CITY OF ALBUQUERQUE

July 1, 2016

**Re: La Cuentista Unit II
Erosion and Sediment Control Plan
Engineer's Stamp Date 6-20-16 (D10E002B)**

**INTERIM EROSION
CONTROL SYSTEM
DETAIL**
SCALE: 1"=20'
BASIL PLACE WEST
STA 4+76 TO STA 5+46

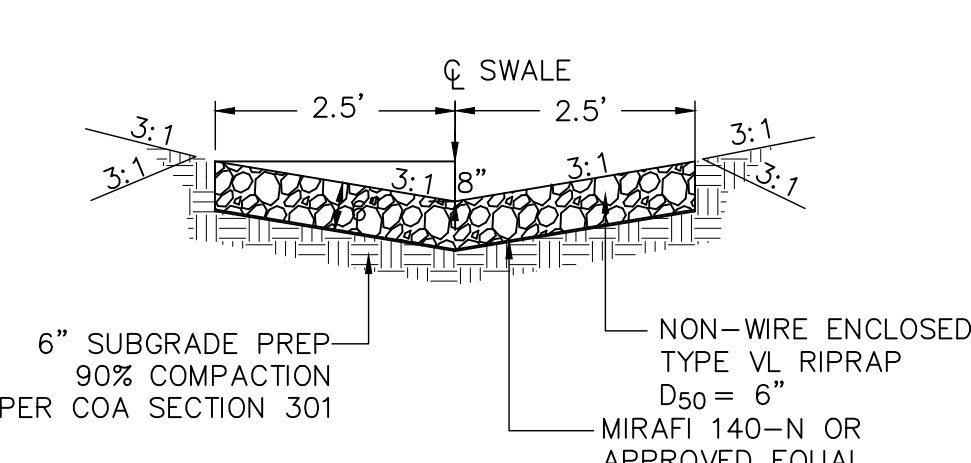
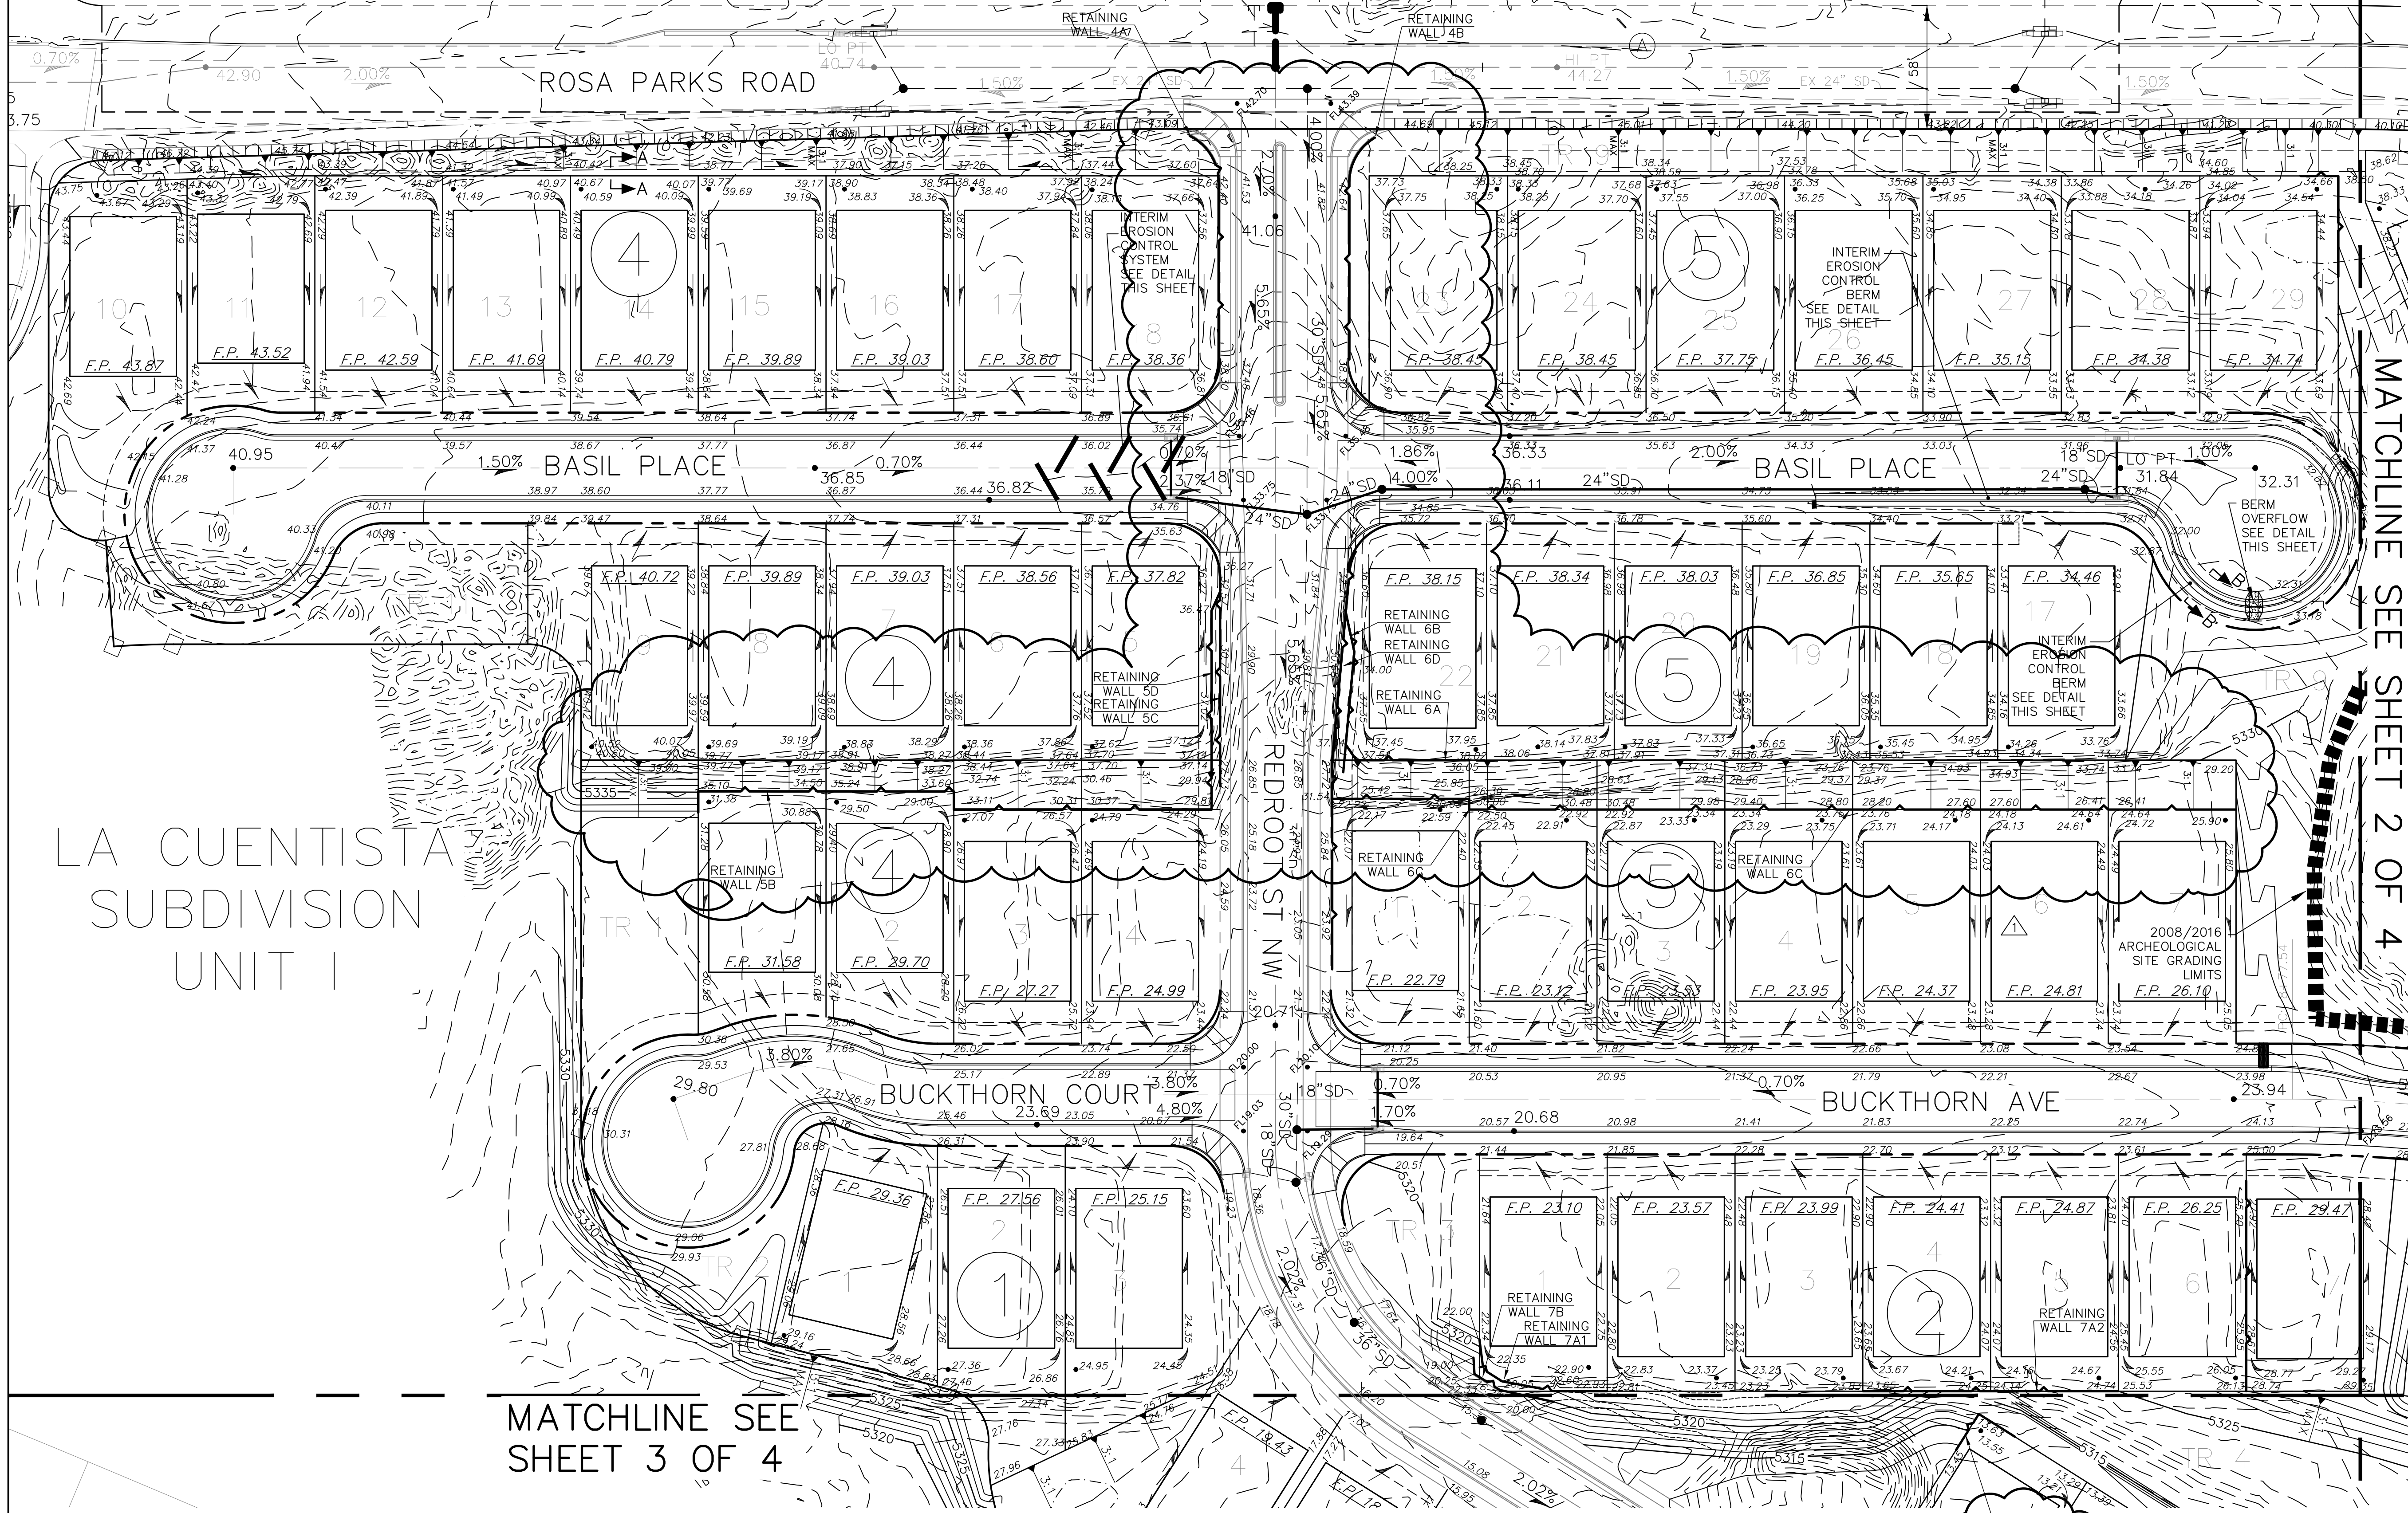
4. Include the interim erosion measure shown on the grading plan on the ESC plan; Interim Erosion Control System Detail and its location on Basil Place and the Coir Roll Detail from Sheet 10 of 32 and the interim measure on Red Clover St.
